CONSTRUCTION PLANS
FOR
**CARRIAGE MEADOW SOUTH AT
LORSON RANCH FILING NO. 2**
STREET/STORM SEWER AND UTILITY CONSTRUCTION PLANS

CORE ENGINEERING GROUP	DATE: _____
	DESCRIPTION: _____
NO. _____	PROJECT: CARRIAGE MEADOWS SOUTH AT LORSON RANCH FILING NO. 2
DRAWN: RLS	PREPARED FOR: LORSON, LLC
DESIGNED: RLS	212 N. WAHSATCH AVE. SUITE 301
CHECKED: RLS	COLORADO SPRINGS, COLORADO 80903
COVER SHEET STREET/STORM SEWER AND UTILITY PLANS	
DATE: DECEMBER, 2018	
PROJECT NO. 100.046	
SHEET NUMBER C0.1	
TOTAL SHEETS: 21

**CARRIAGE MEADOWS SOUTH AT LORSON RANCH FIL NO. 2
 UTILITY SERVICES PLAN**

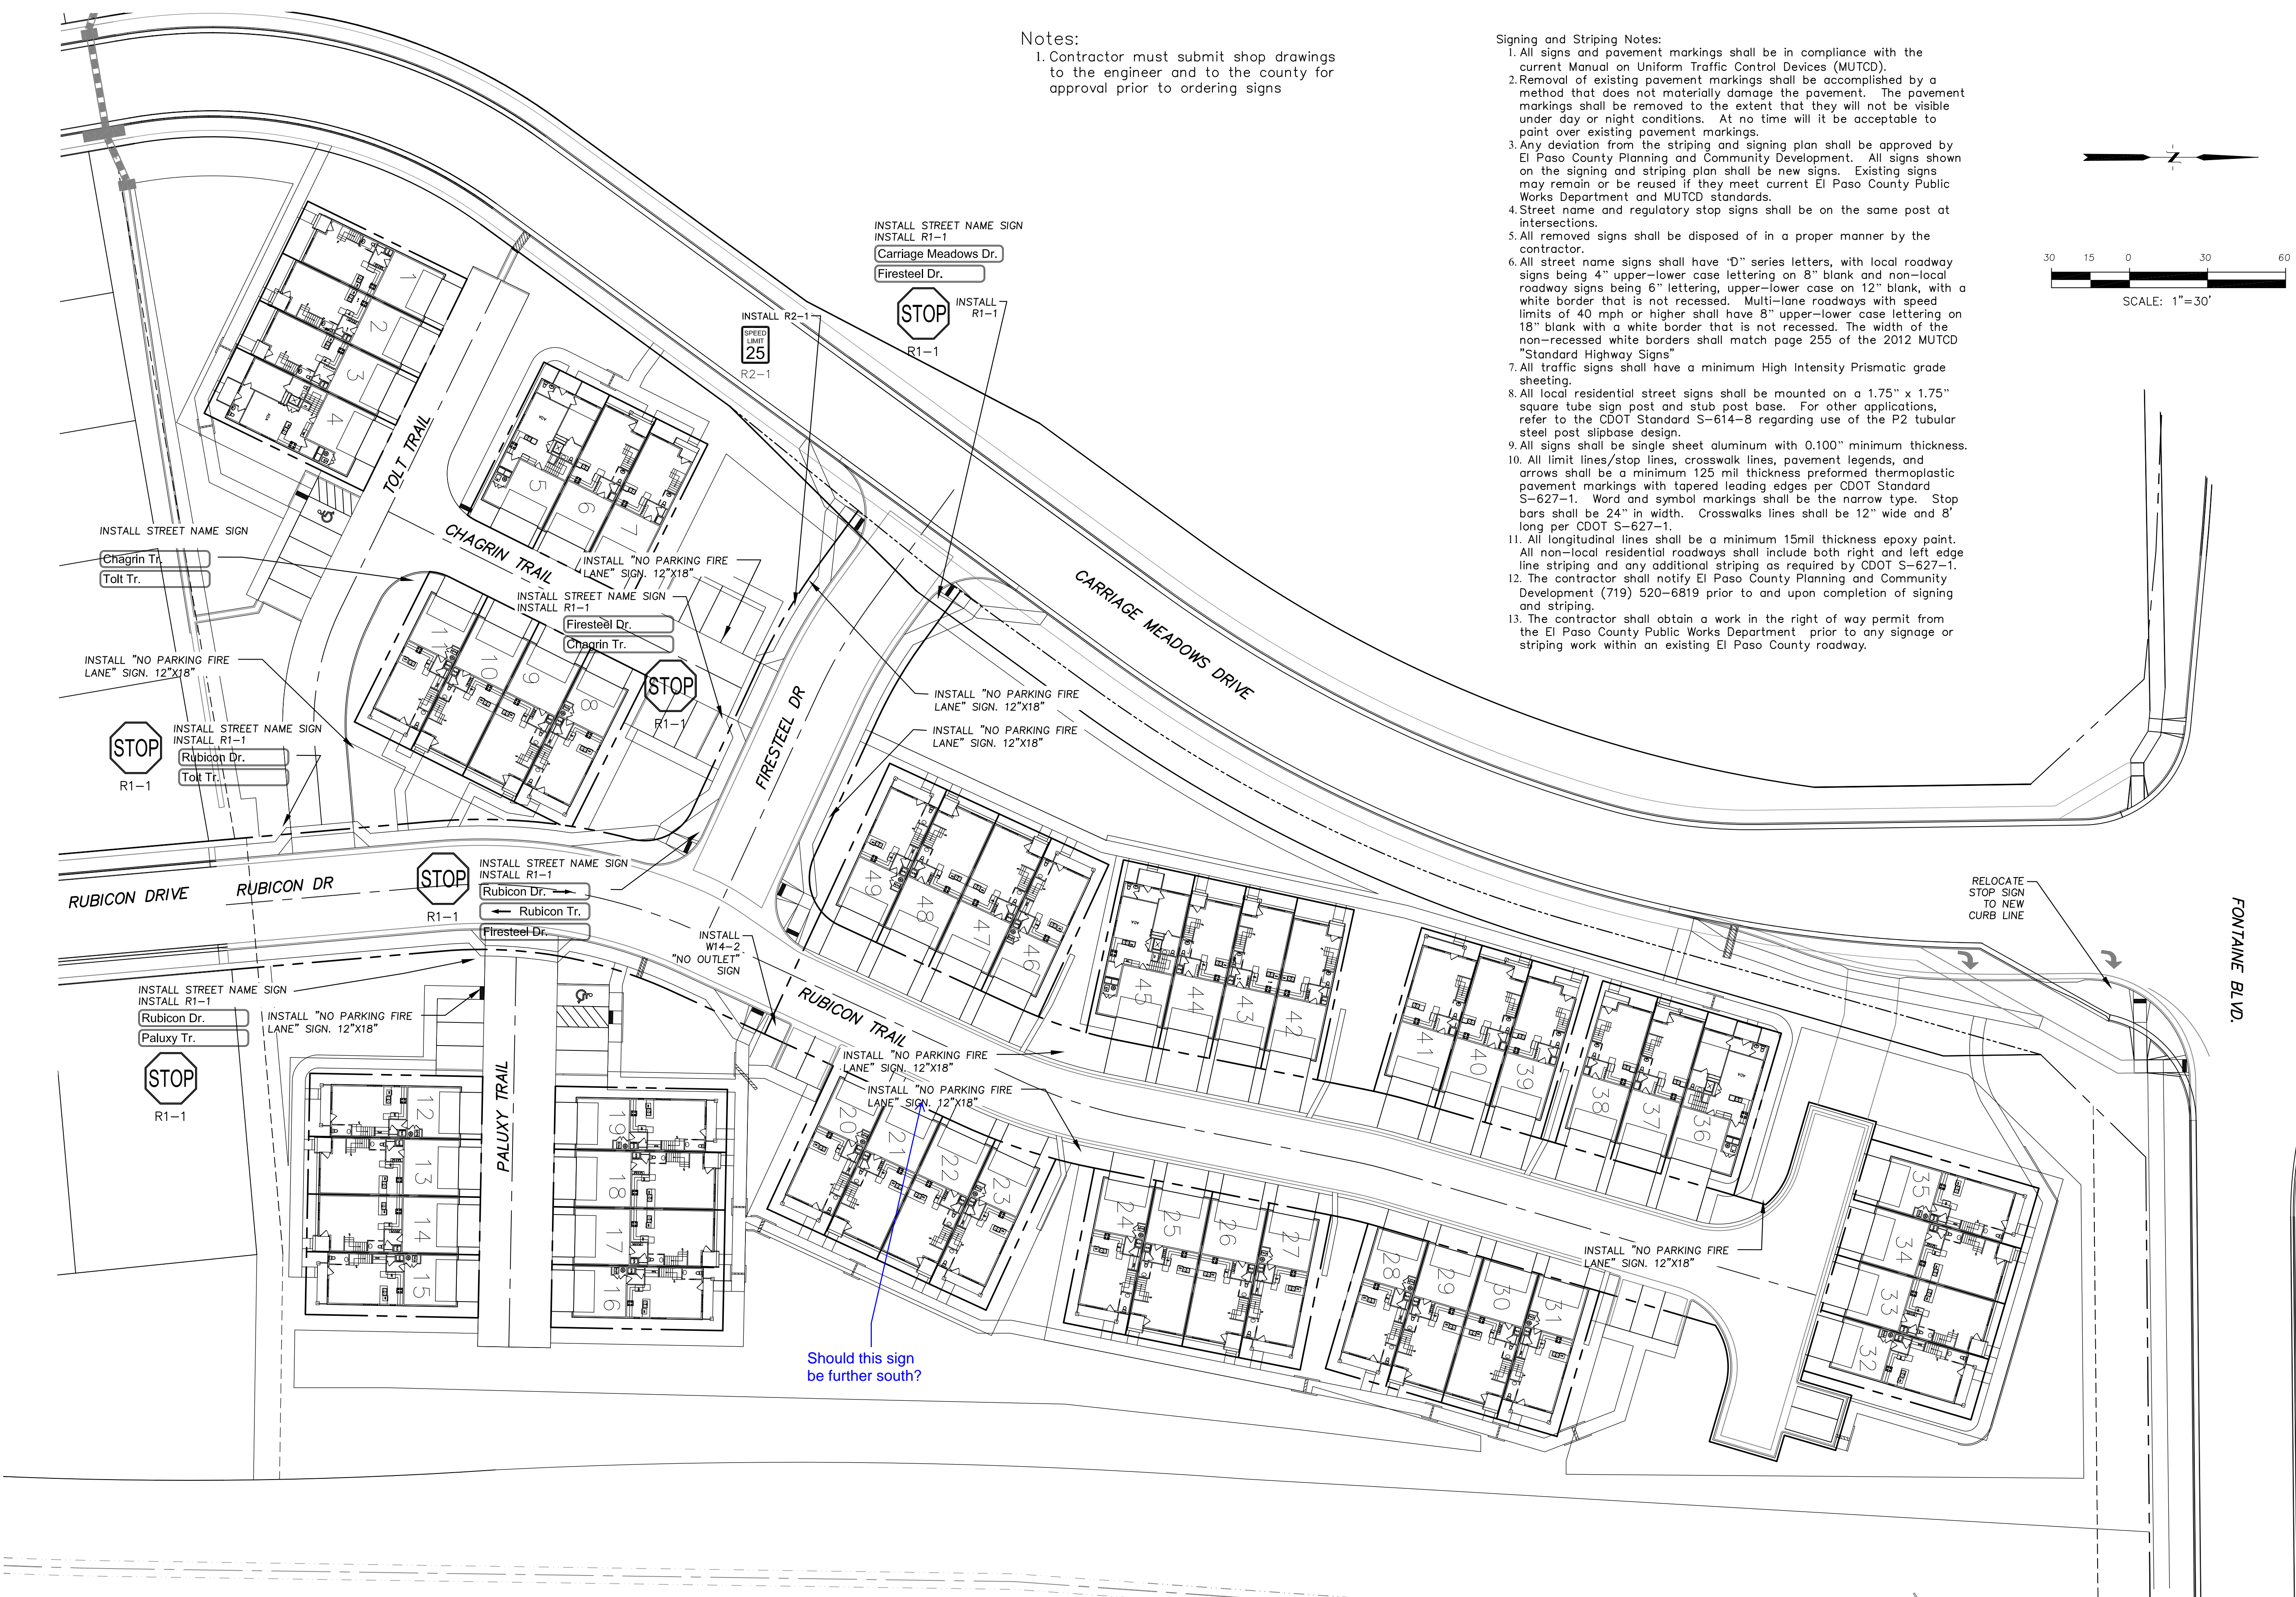
These plans need to show the necessary construction of Carriage Meadows Drive including a Left Turn lane into the site as called out in the Traffic Study,
